CITY OF ALBUQUERQUE

RE: Lands of Joe Grady
3815 Pedroncelli Rd. NW
Grading & Drainage Plan
Engineer's Stamp Date: no stamp/no date
Hydrology File: F13D038
Case # HYDR-2025-00095

Based upon the information provided in your submittal received 03/24/2025, the Grading & Drainage Plan is **not** approved for Grading Permit, Building Permit, or action by the DFT/DHO for platting action. The following comments need to be addressed for approval of the above referenced project:

TITLE: GRADING PLAN
LANDS OF JOE GRADY

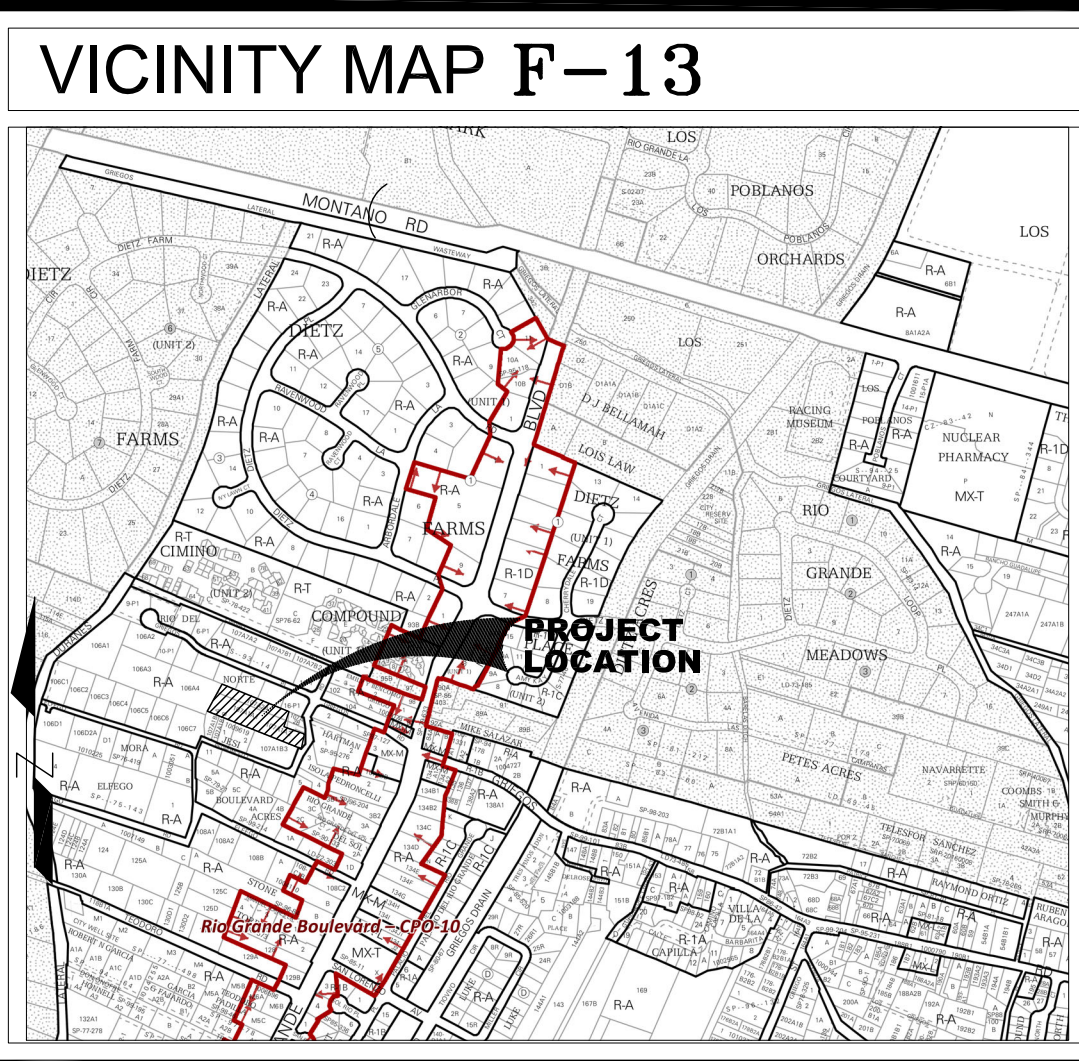
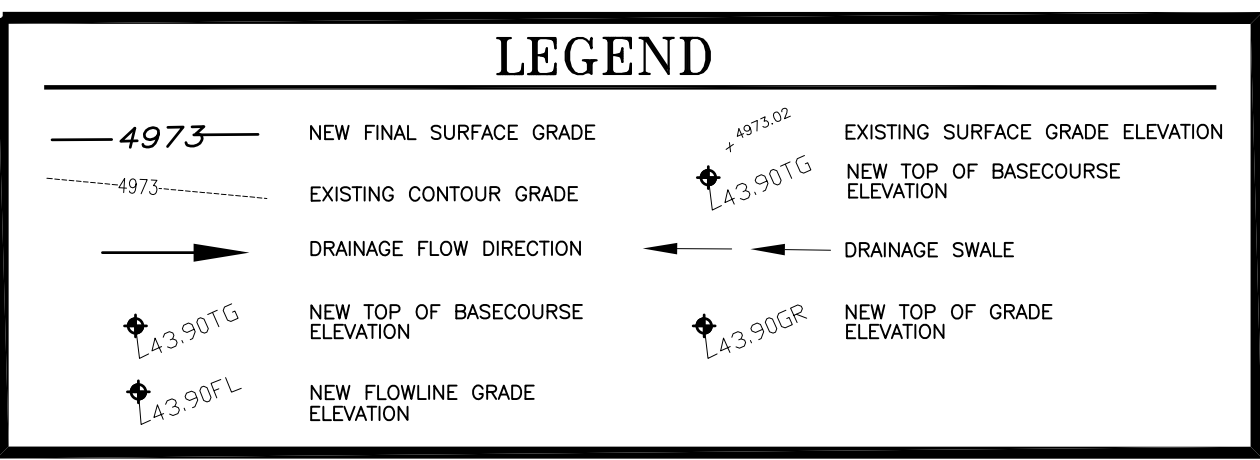
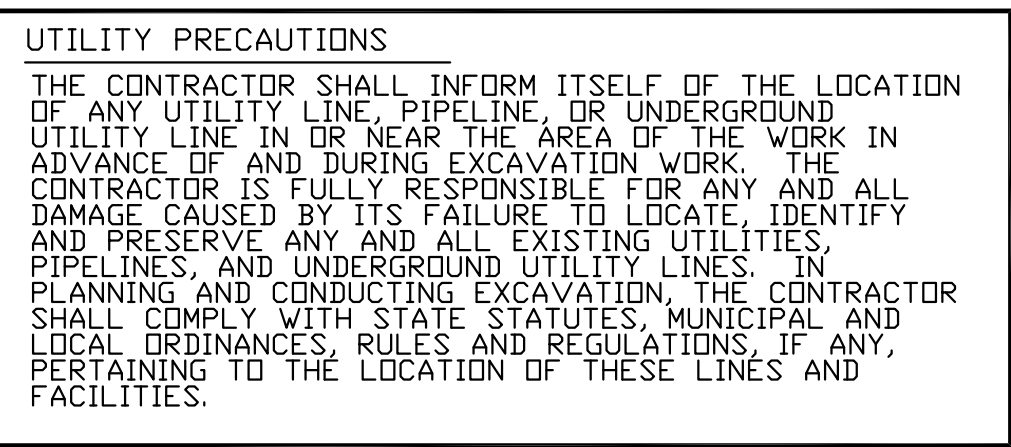
1. Per the DPM, the following must be on the Grading Plan. Please note the Grading Plan must be a stand-alone construction document.
 - Please provide a licensed New Mexico civil engineer's stamp with a signature and date.
2. Since this site is in the Valley region, please follow Article 6-5 Valley Drainage Criteria of the DPM. The following conditions must be applied to the site:
 - A permanent perimeter wall or barrier around the development is required to contain the 100 year 24 hour storm developed runoff
3. Please check the calculation section for LOT 2 to ensure consistency with Pond Volume Required and Pond Volume Provided.

LOT 2:
TOTAL AREA OF LOT = 0.442ACRES
TYPE "D" TREATMENT = PROPOSED ROOF AREAS (3,600SF) + PROPOSED CONCRETE AND PAVED AREAS (2,000SF) = 5,600SF = 0.129AC
TYPE "C" TREATMENT = REMAINING DISTURBED AREAS COMPACTED BY HUMAN ACTIVITY = 0.442AC - 0.129 = 0.313AC
TREATMENT AREA(ACRES)
A 0
B 0
C 0.31
D 0.13
 $Q(PROPOSED-6HR) = (3.05 \times 0.31) + (4.34 \times 0.13) = 1.51 CFS (6HR) PROPOSED ONSITE FLOW$
 $V(PROPOSED-6HR) = ((1.03 \times 0.31) + (2.33 \times 0.13)) / 12 = 0.052AC-FT$
 $= 2.259CF PROPOSED VOLUME$
 $V(PROPOSED-10DAYS) = V(6HR) + ((A(I)MP) \times (P(10DAYS) - P(6HR)) / 12IN/FT$
 $P(6HR) = 2.29IN P(10DAY) = 3.62IN$
 $V(PROPOSED-10DAYS) = 0.052AC-FT + ((0.13) \times (3.62IN - 2.29IN) / 12IN/FT = 0.066AC-FT$
 $V(PROPOSED-10DAYS) = 0.066AC-FT \times 43,560CF/AC = 2,892CF POND VOLUME REQUIRED FOR DEVELOPED CONDITIONS$

PROPOSED RETENTION POND VOLUME PROVIDED FOR LOT 2				
ELEV.	AREA(SF)	AVG. AREA(SF)	DEPTH(FT)	VOLUME(CF-FT)
4972.2 BTM	3,479			
		4,989	0.8	3,991
4973.0 TOP	6,499			
				2,795C

PROPOSED RETENTION POND VOLUME PROVIDED = 2,795CF > 2,500CF
RETENTION POND REQUIRED FOR LOT 2 OK
